### STOP WORK NOTICE

May 27, 1999

RE: 7 Robin St  
CBL: 272-G-001

SITE AND UTILITY PLAN
1"=30'

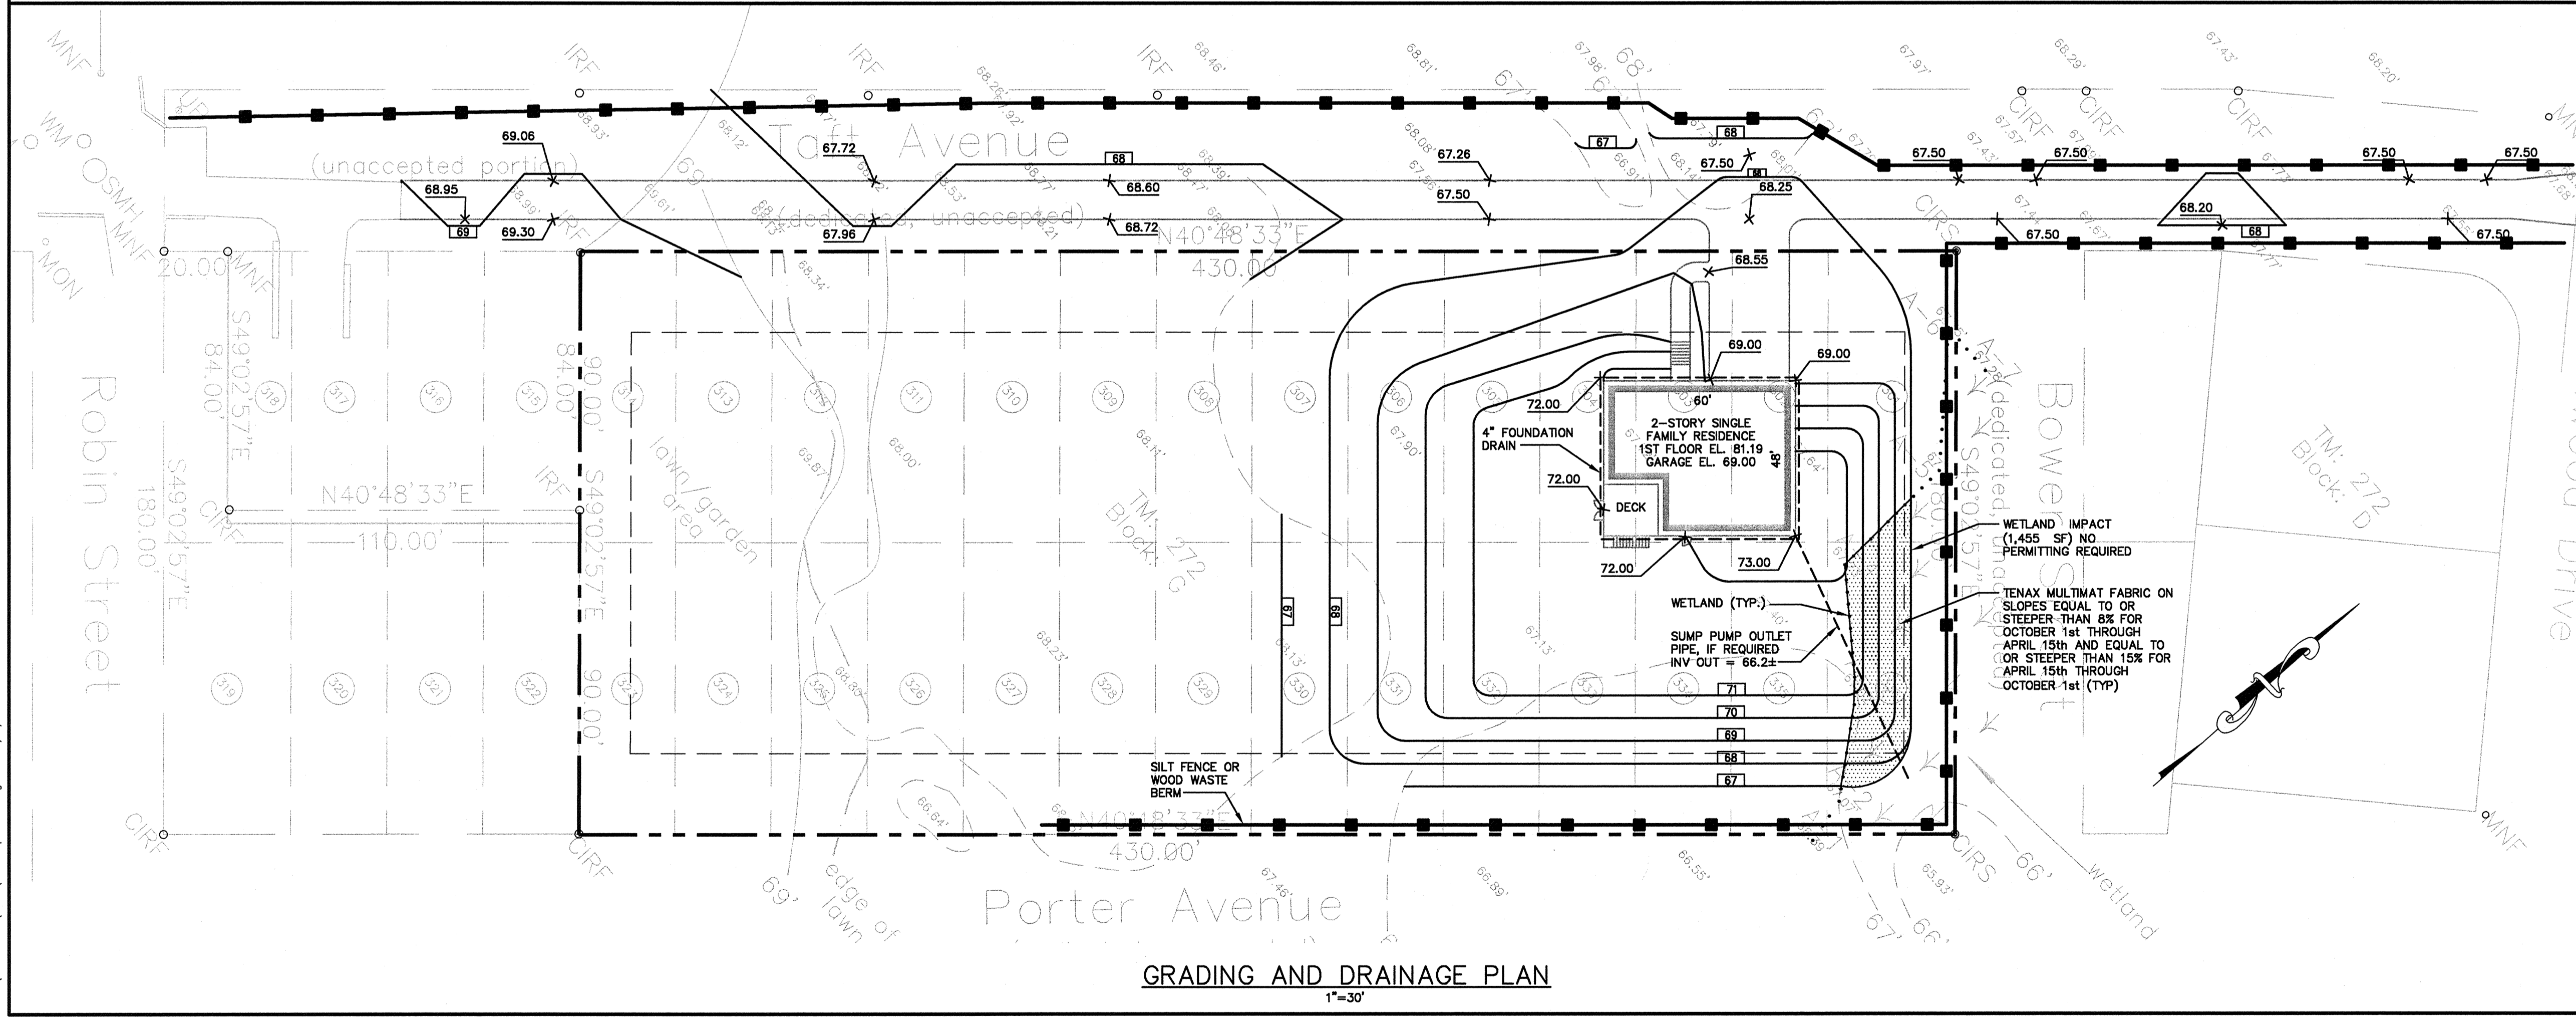
Footing is not located to meet the setback requirements of the R3 City of Portland Zoning Ordinance. You must submit within 30 days a new site plan that will give you proper setbacks or relocate the footing to they meet setbacks. You can have this verified by a Licensed Surveyor.

Therefore, you are required to submit amended construction and site plans to this office for review and approval. You must also submit a list of all subcontractors on the job with their addresses and telephone numbers. When you have received approval of the amended plans and submitted the requested subcontractor information you may request removal of the "STOP WORK" order. Failure to comply will result in this office referring the matter to the City of Portland Corporation Counsel for legal action and possible civil penalties, as provided for in Section 1-15 of the Code and in Title 30-A M.R.S.A. ss 4452.
